Our ref: 22/0031/INVAL
Your ref:

27 January 2022

Certificate of Lawful Use (Proposed) to a Listed Building: Installation of Air Conditioning/Heating Units at Christchurch Farm Sixteen Foot Bank Christchurch Wisbech Cambridgeshire PE14 9NJ

Drawing Title:	Site Plan
----------------	-----------

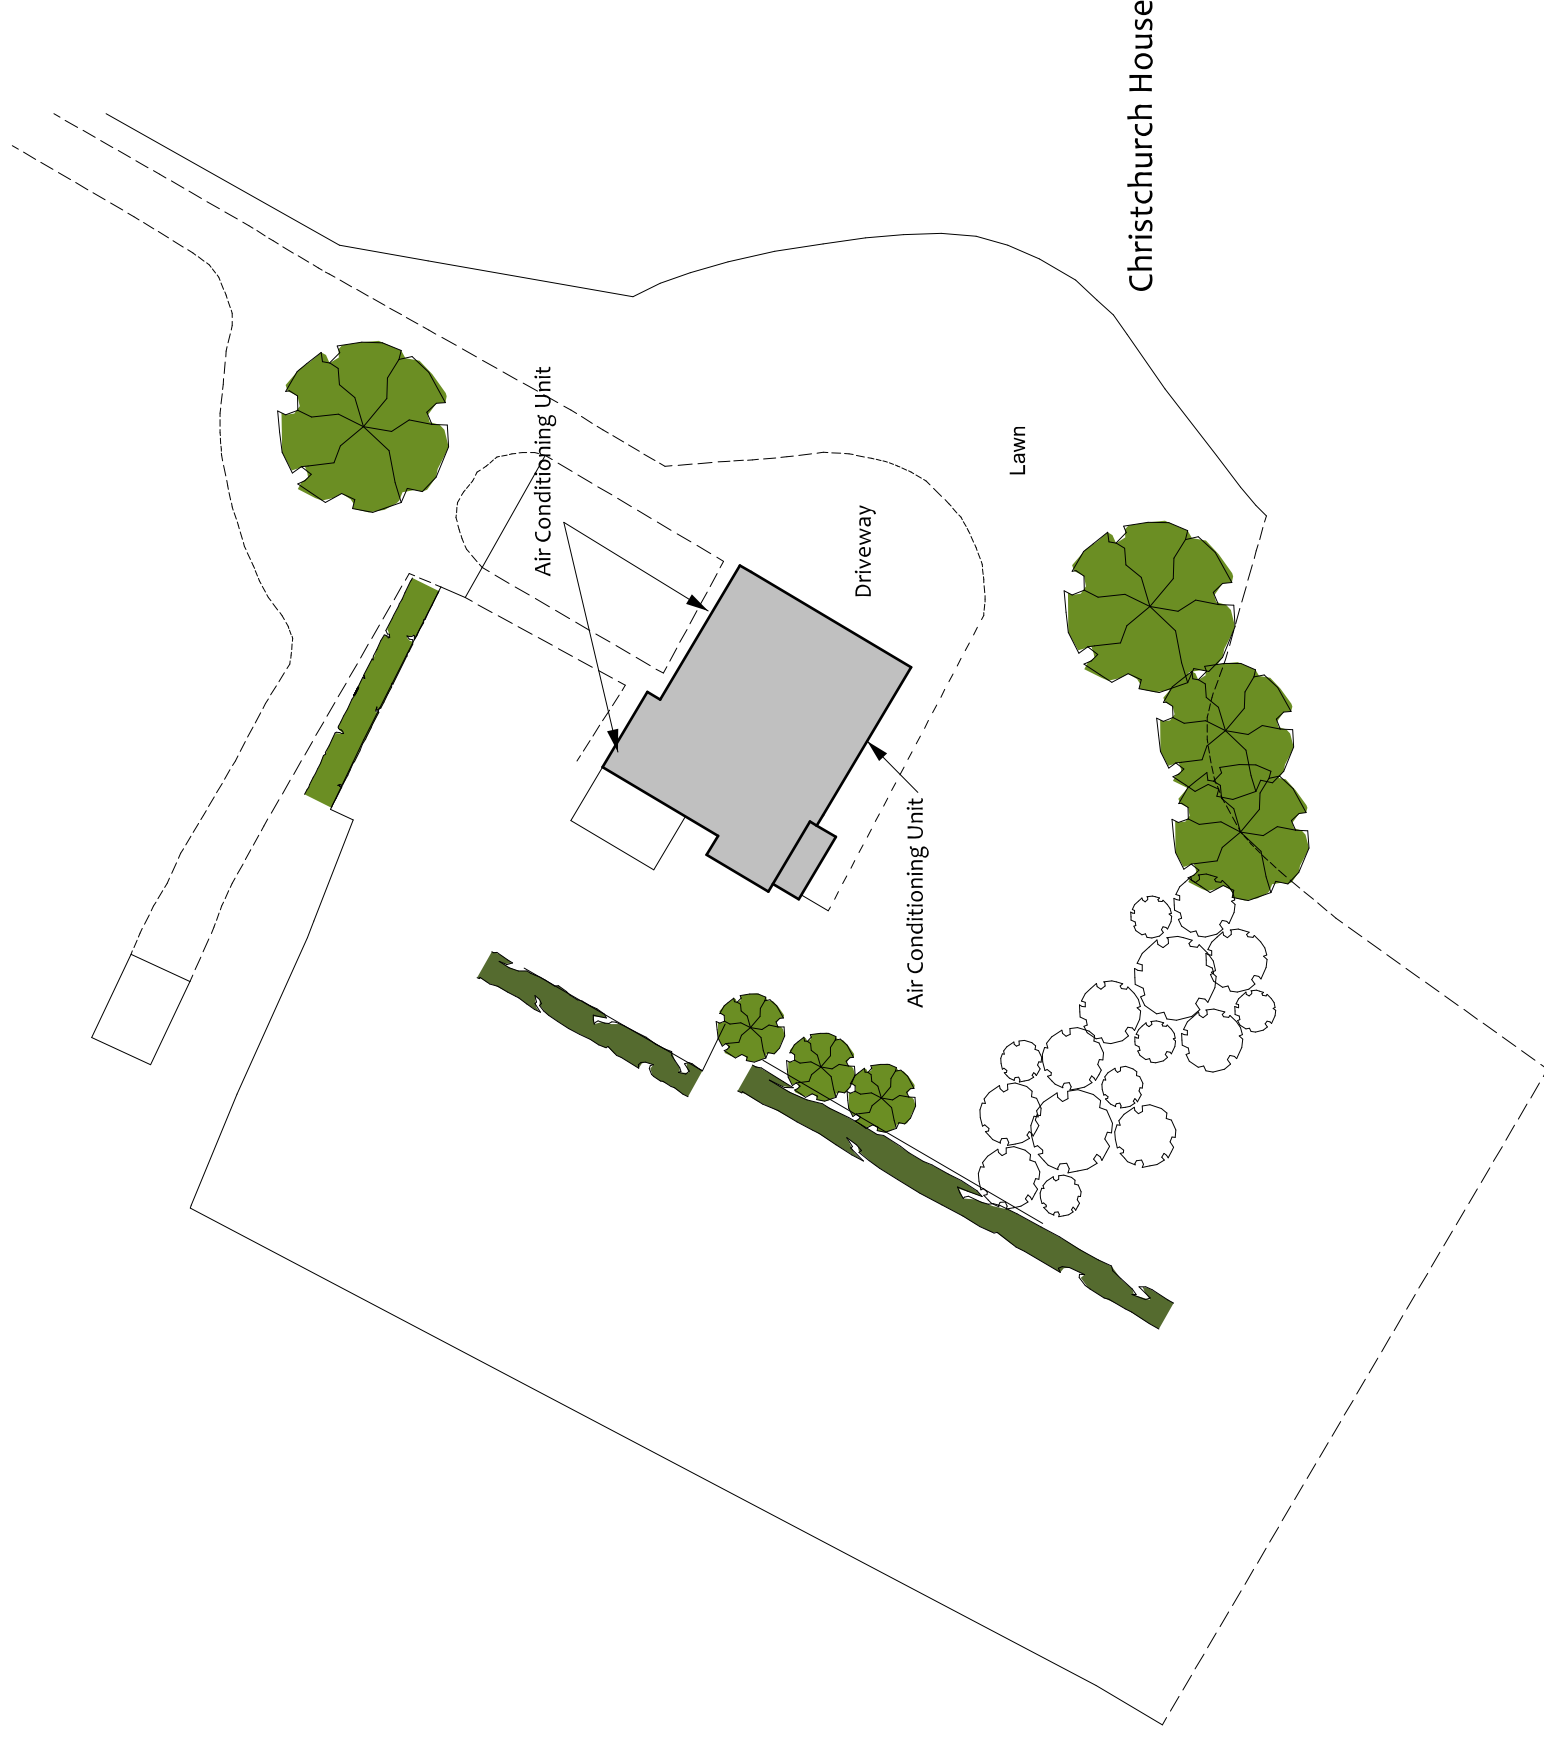
2 Block Plan

A block plan is required as part of this application, showing the proposal in relation to existing features surrounding the site.

Please indicate your proposal on the plan.

Drawing Title: Existing and Proposed Elevations

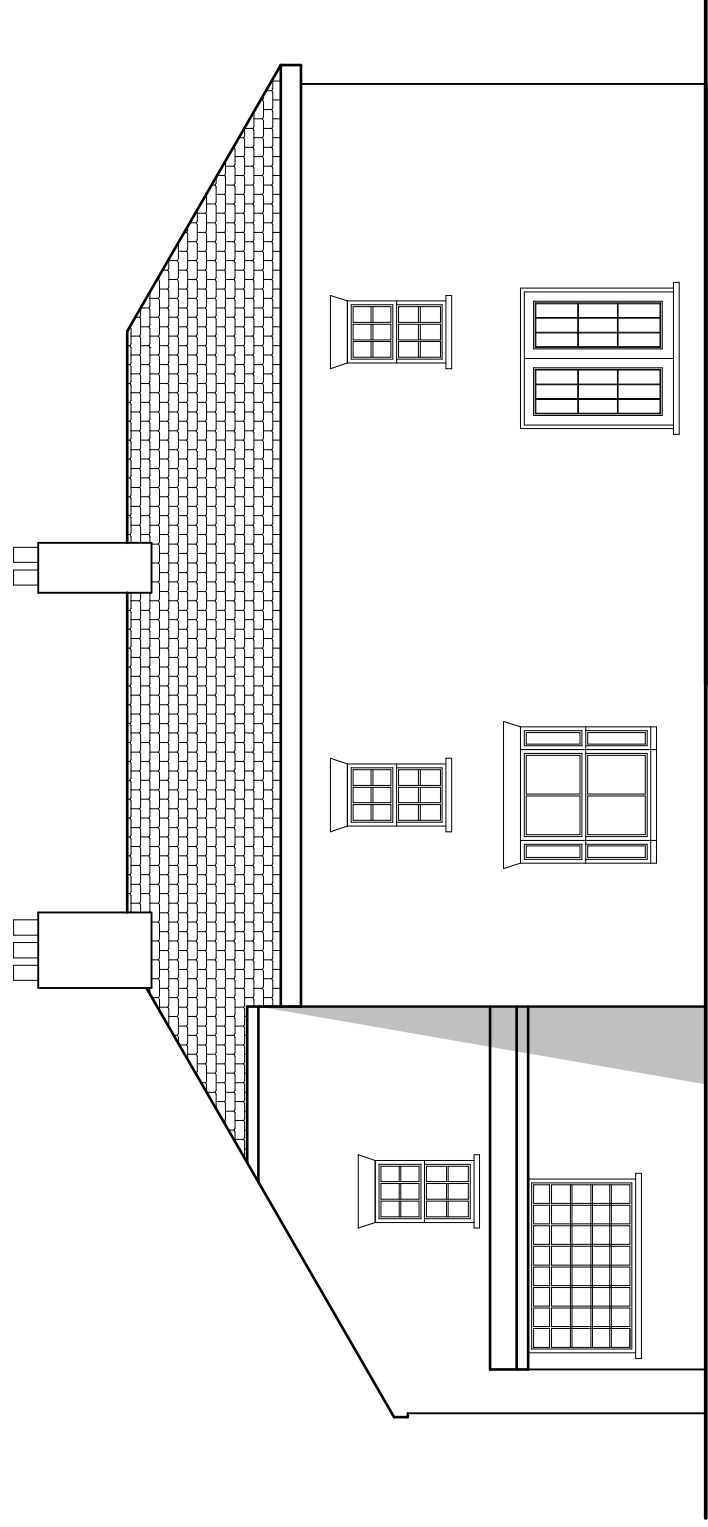
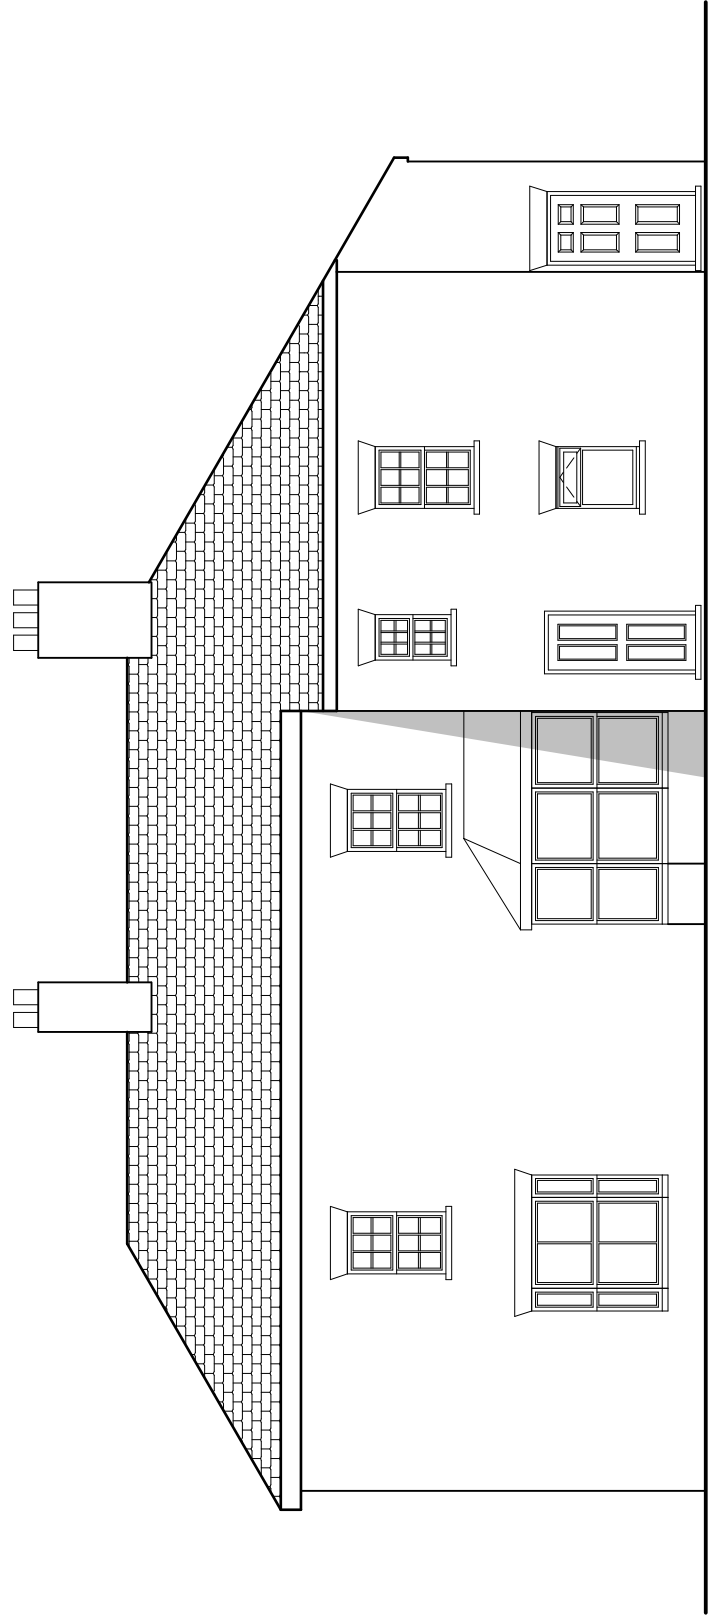
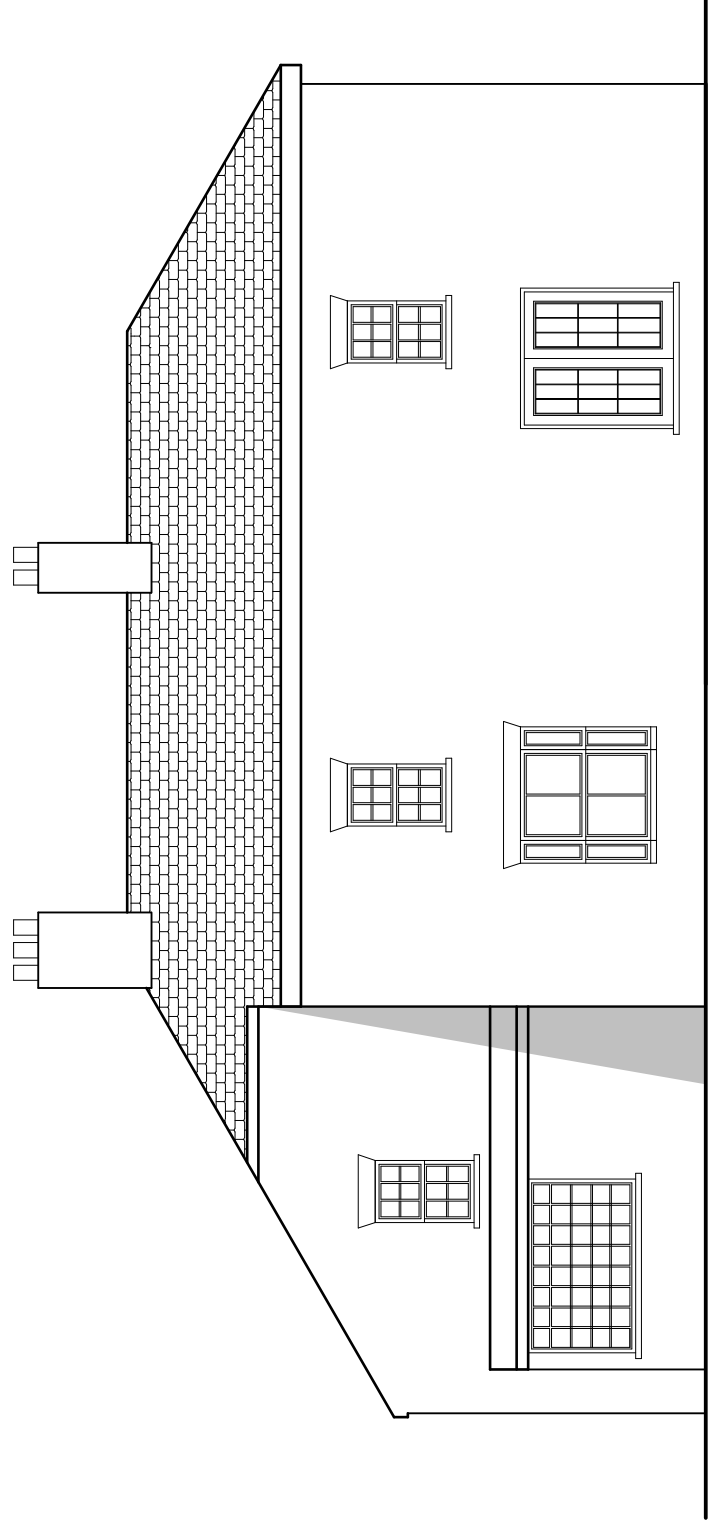
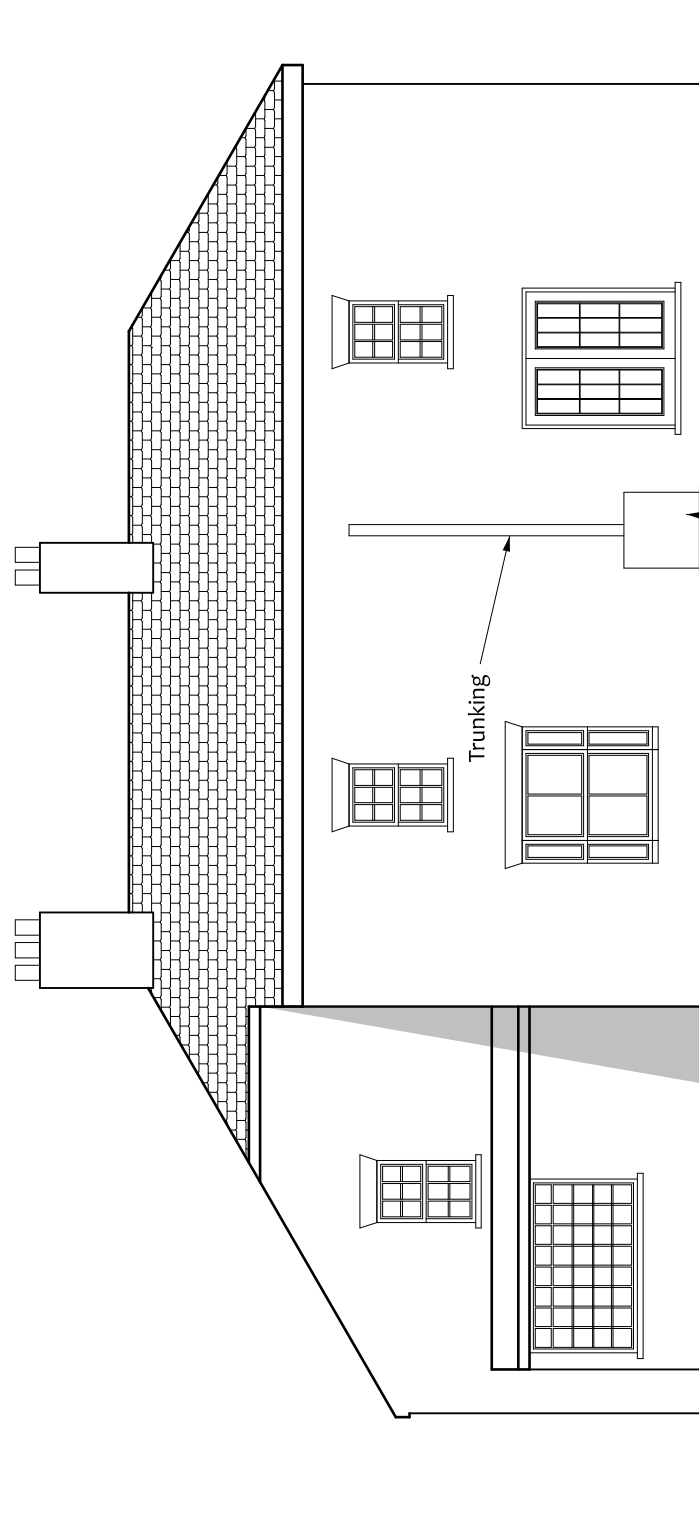
3 Existing and Proposed Elevations

Elevation drawings are required as part of this application. All drawings must be to a recognised scale of 1:50 or 1:100 and be correctly labelled to indicate whether they are north, south, east or west elevations. All elevations that are to be altered as a result of the proposed works are required.

This is to enable us to accurately site the equipment on/adjacent to the building and to accurately assess its visual impact.
